**APP CORPORATION PTY LIMITED**

**INTERIM EXHIBITION FACILITY  
GLEBE ISLAND EXPO**

**ACCESS REPORT**

12<sup>th</sup> November 2012

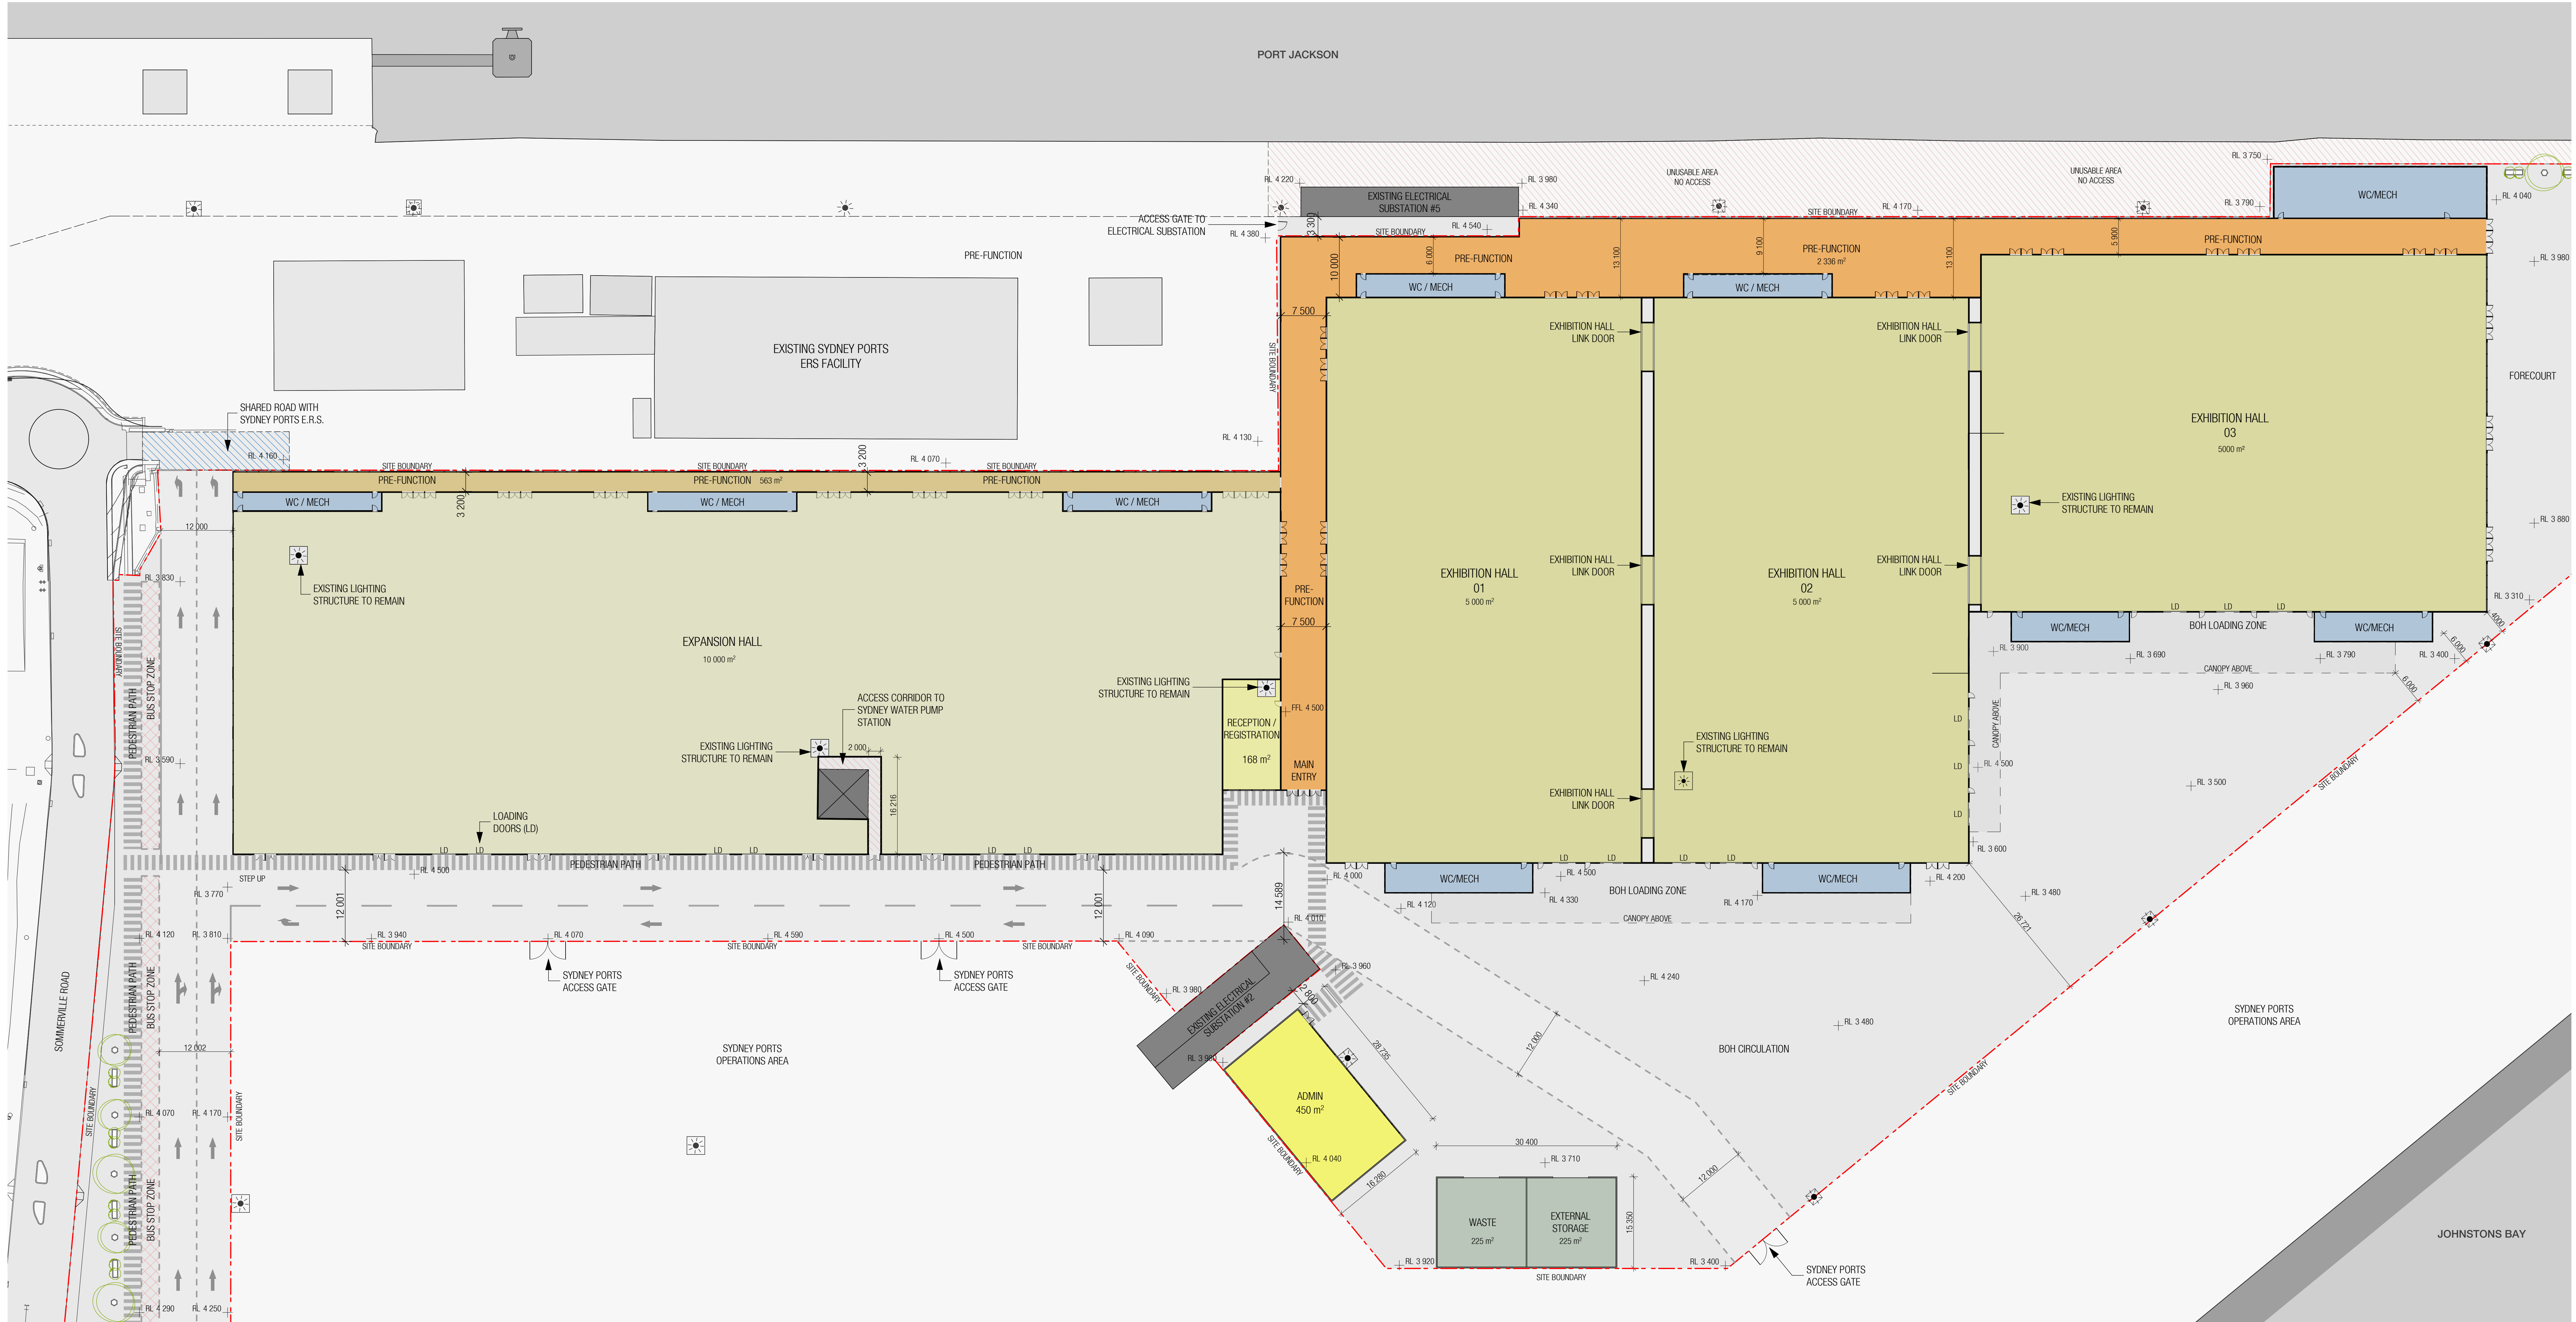
The open area in front of the main entrance (adjacent the existing electrical substation 2) appears to provide sufficient space for a taxi/car drop-off area. As there is no pedestrian site access provided, the provision of a drop-off area near the main entrance of the facility would improve the accessibility to the facility for people with a disability, who have no private vehicle or access to the entry points of the private ferry.

- (i) As there is no pedestrian site access provided, ensure a drop-off area is provided near the main entrance of the interim exhibition facility that could be used for people with a disability.
- (ii) Ensure the drop-off area is accessible for people with a disability, in accordance with DDA Premises Standards.
- (iii) Ensure the path of travel from the drop-off area to the main entrance of the interim exhibition facility is accessible for people with a disability, in accordance with DDA Premises Standards and AS1428.1-2009.

CAR PARK A
SCALE 1:1000

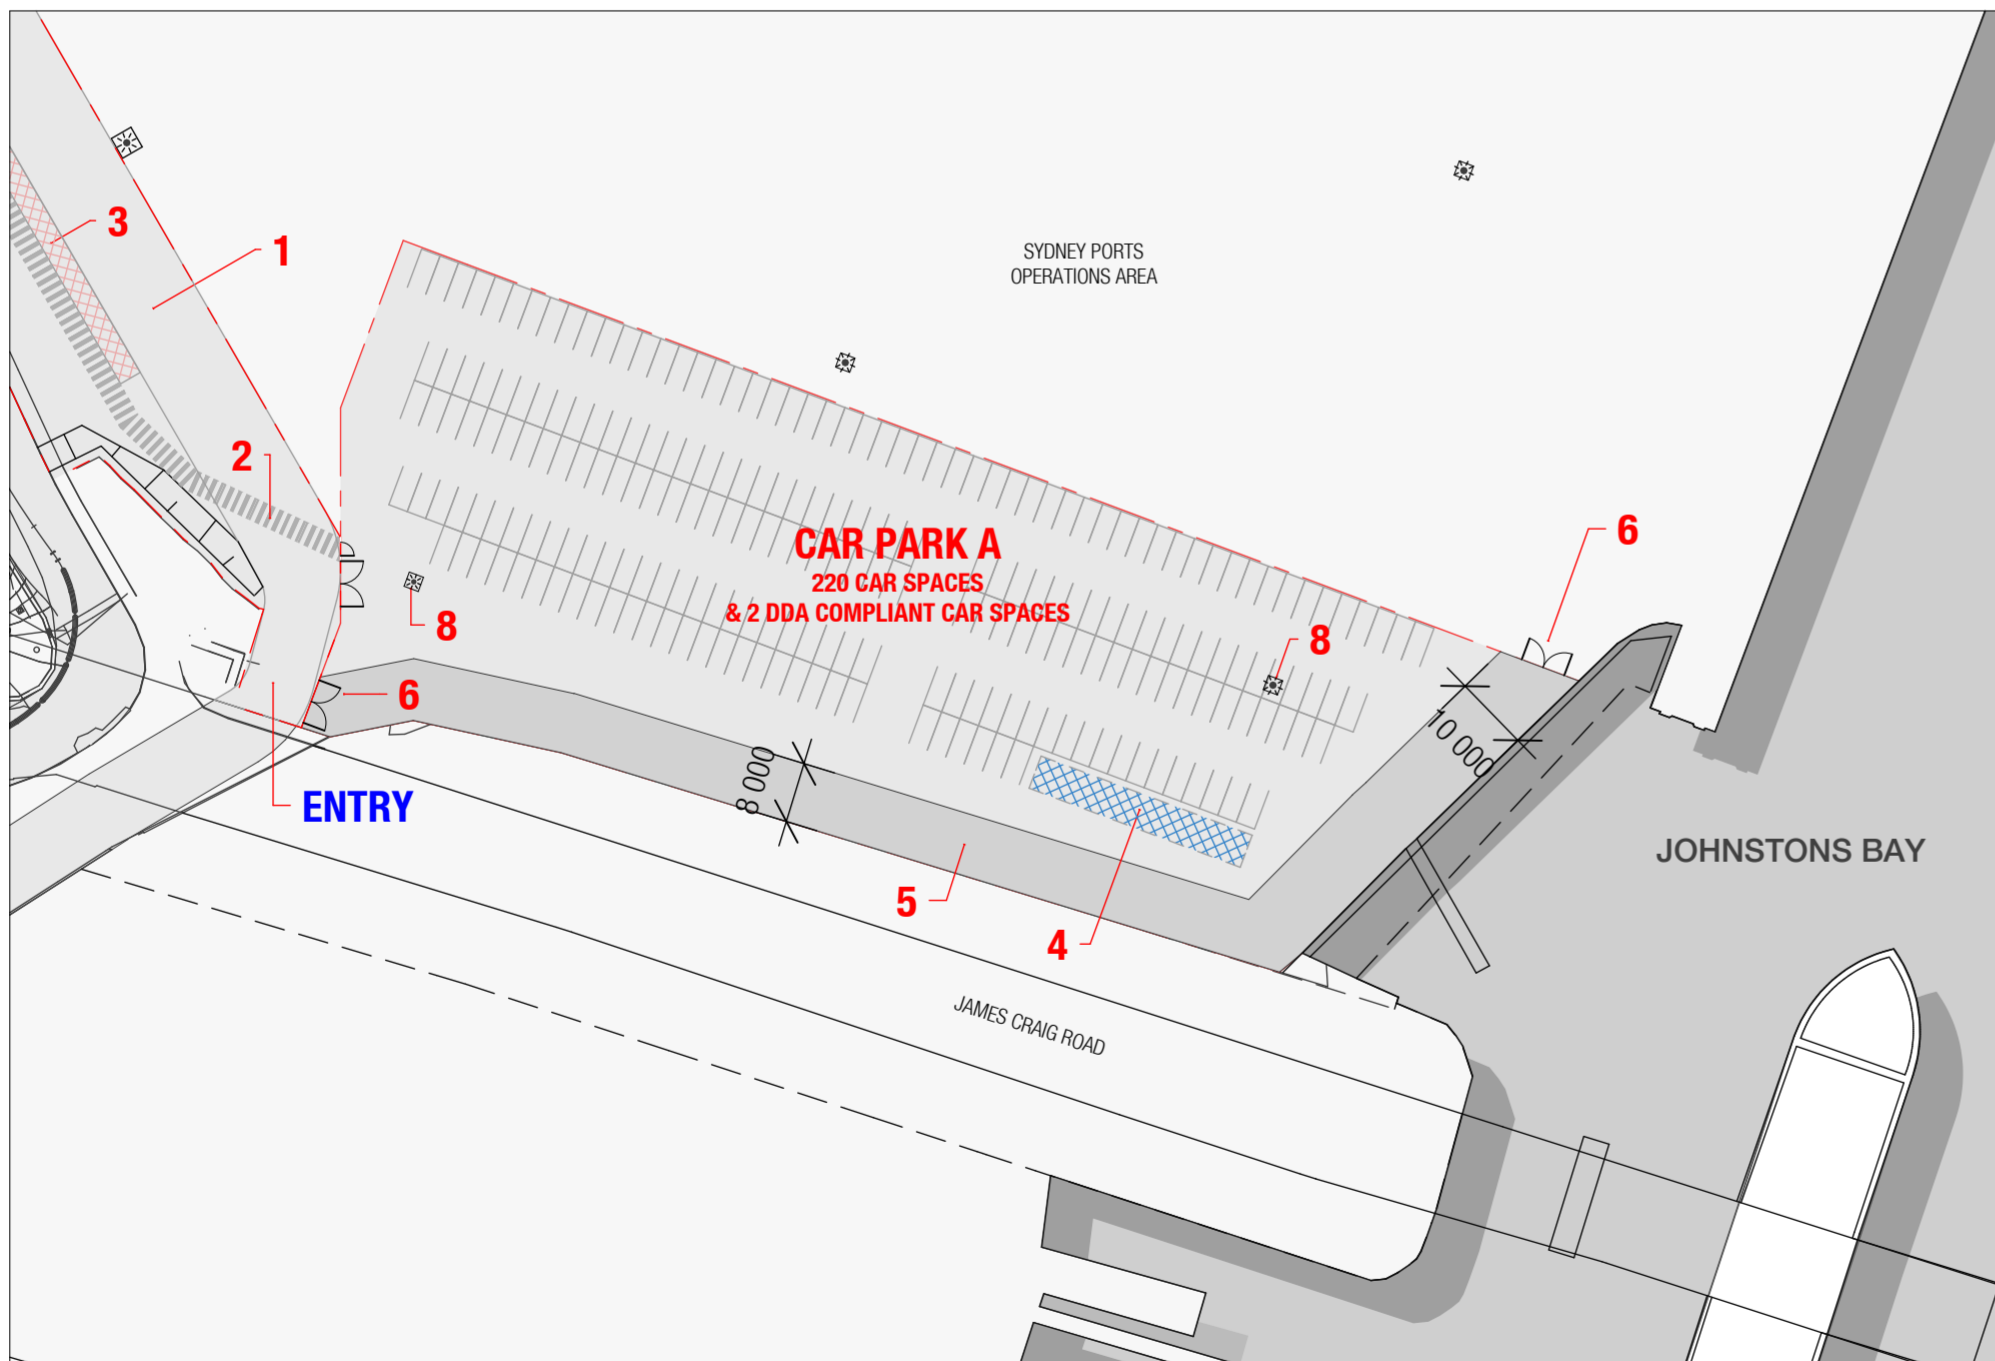
There is a designated pedestrian path provided from Car Park A, to allow for a safe continuous accessible path of travel from the accessible car parking bays in Car Park A (when provided) to the main entrance of the interim exhibition facility.

- (iii) Provide a continuous accessible path of travel from the accessible car parking bays in Car Park D to the main entrance of the interim exhibition facility, compliant with AS1428.1-2009 and DDA Premises Standards.
- (iv) Ensure the pedestrian footpath from Car Park A is accessible for wheelchair users, when accessible car parking spaces are provided in this car park, compliant with AS1428.1-2009 and DDA Premises Standards.

CAR PARK D
(FOR STAGED CONSTRUCTION SCENARIO)
SCALE 1:1000

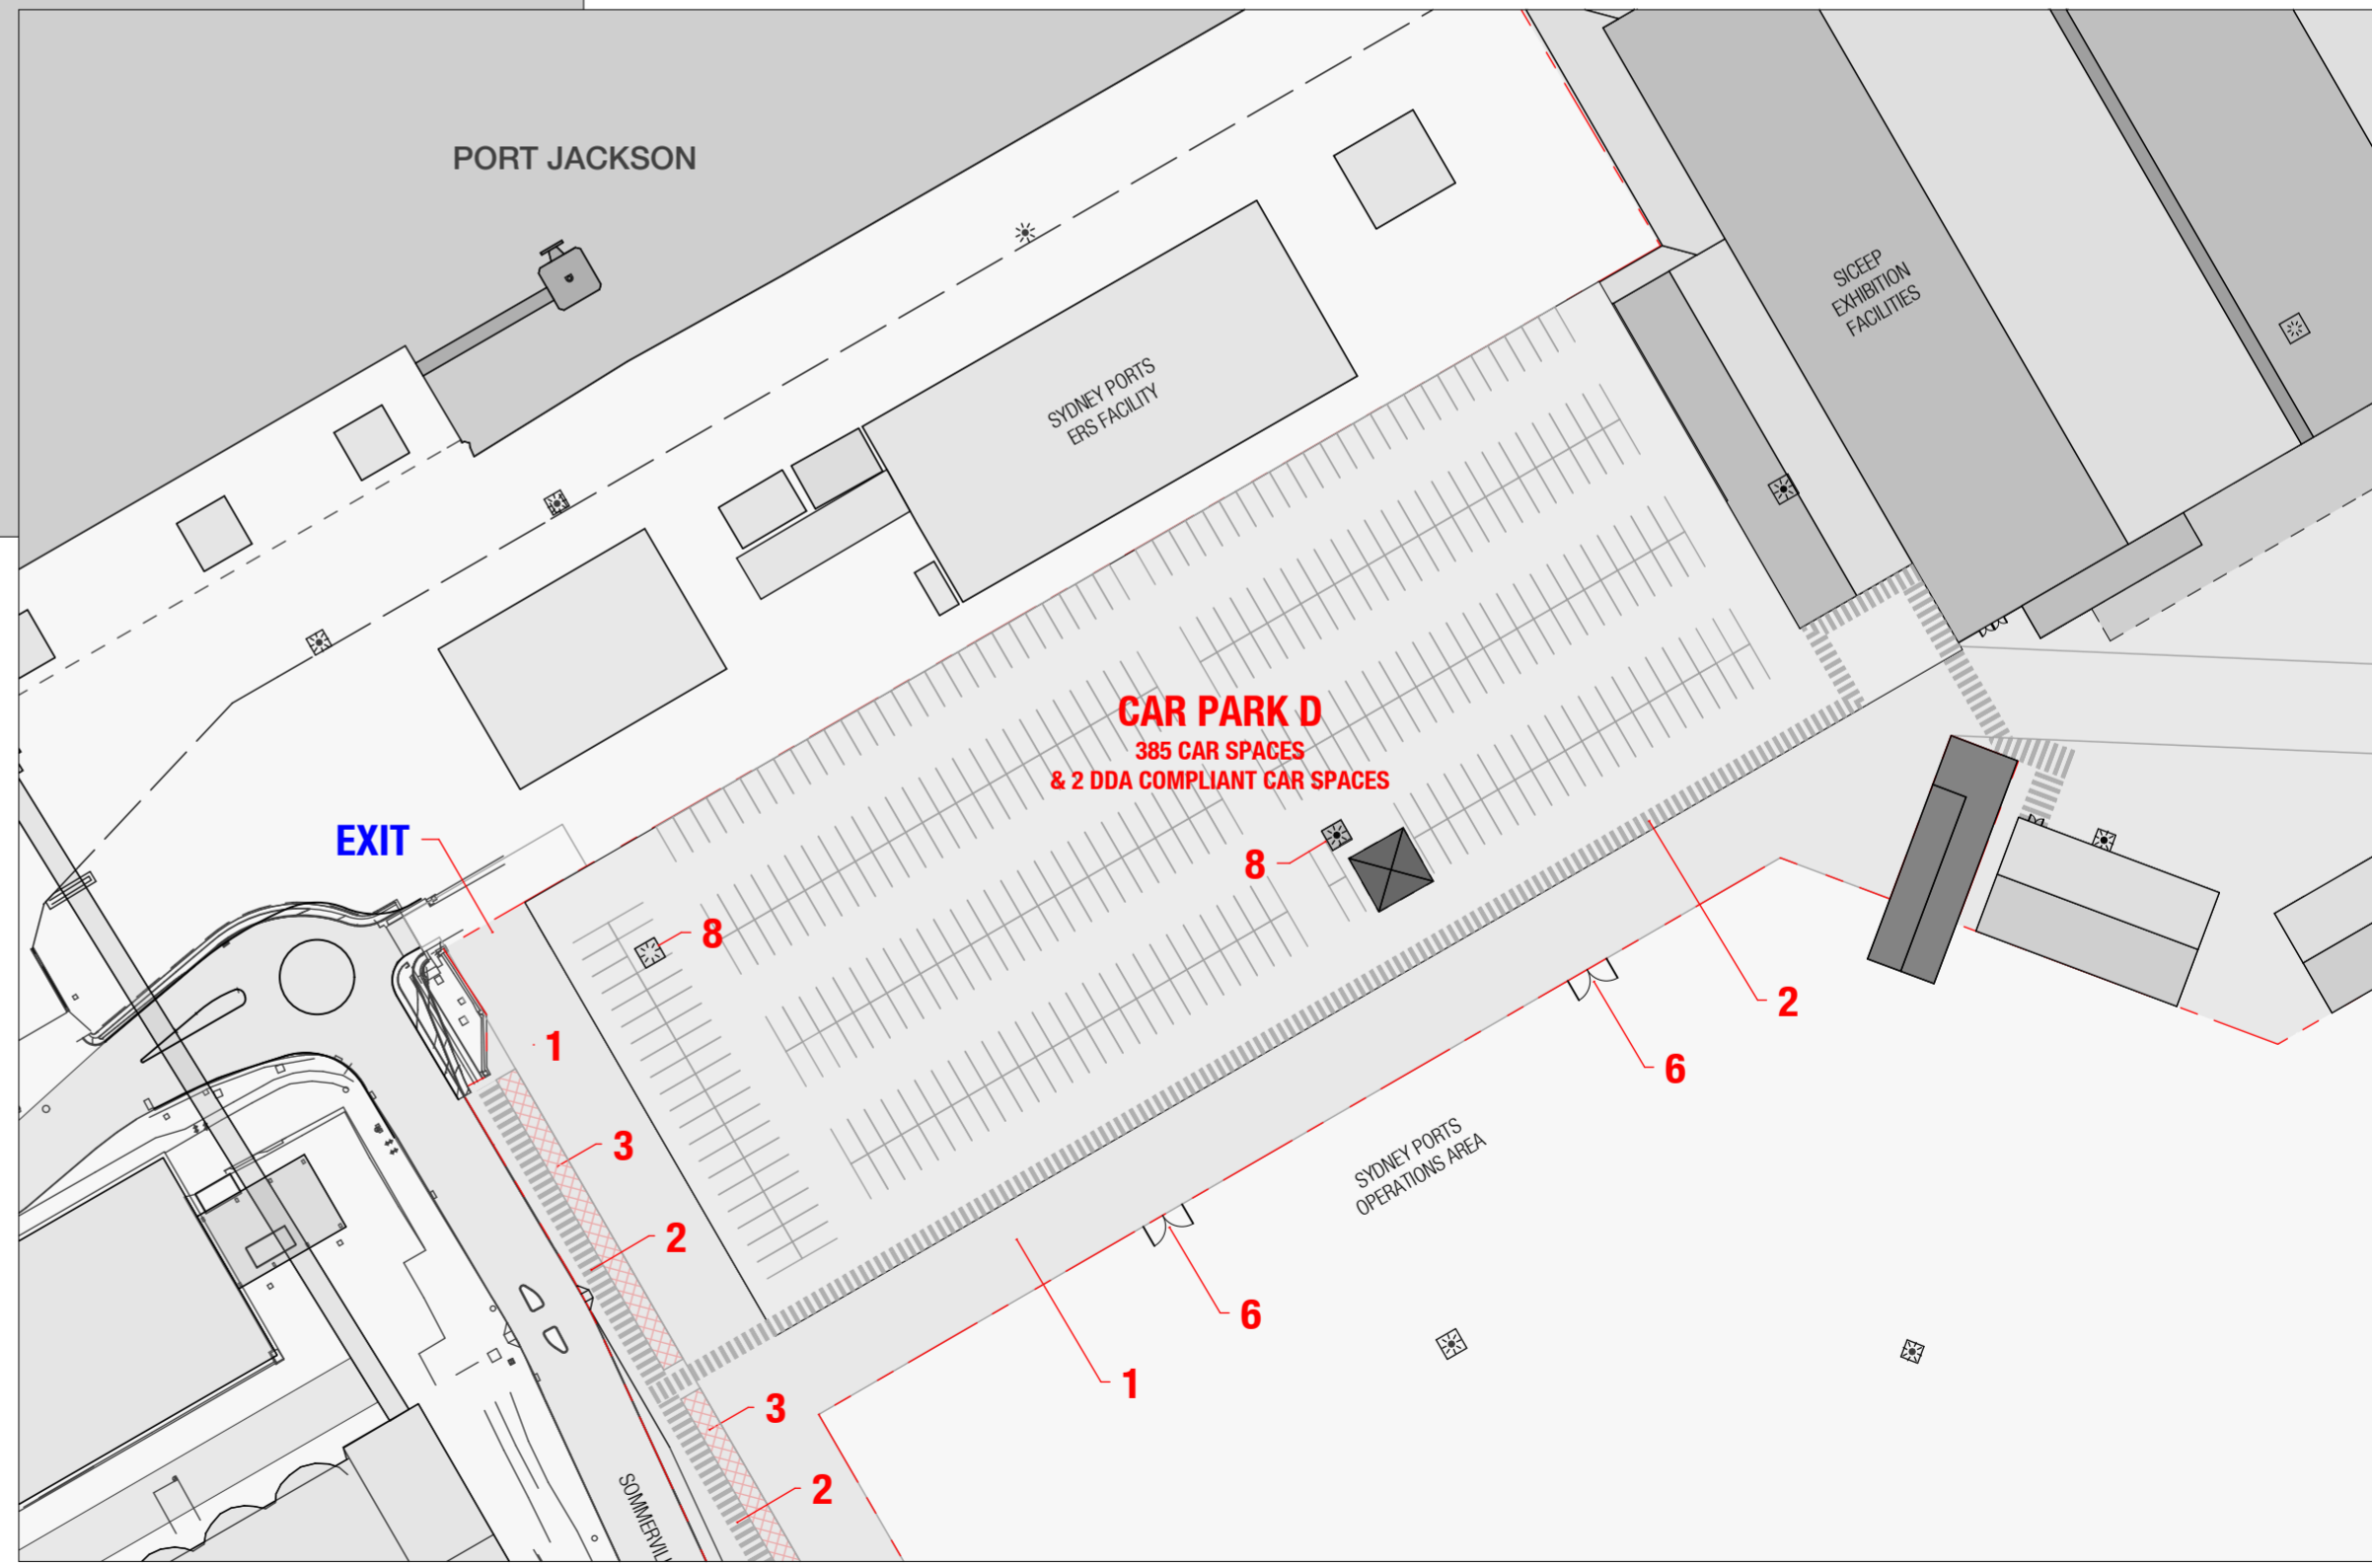
- (i) Ensure 2% of the total capacity of car parking for the interim exhibition facility is designated as accessible car parking bays, compliant with BCA/DDA Premises Standards D3.5.
- (ii) Ensure all accessible car parking spaces are provided in Car Park D, near the main entrance of the facility, compliant with AS2890.6-2009.

However, if the total area reserved for the hall expansion is used for exhibitions, the accessible car parking bays will need to be provided in Car Park A (near the pedestrian entry point of the car park), compliant with AS2890.6-2009.
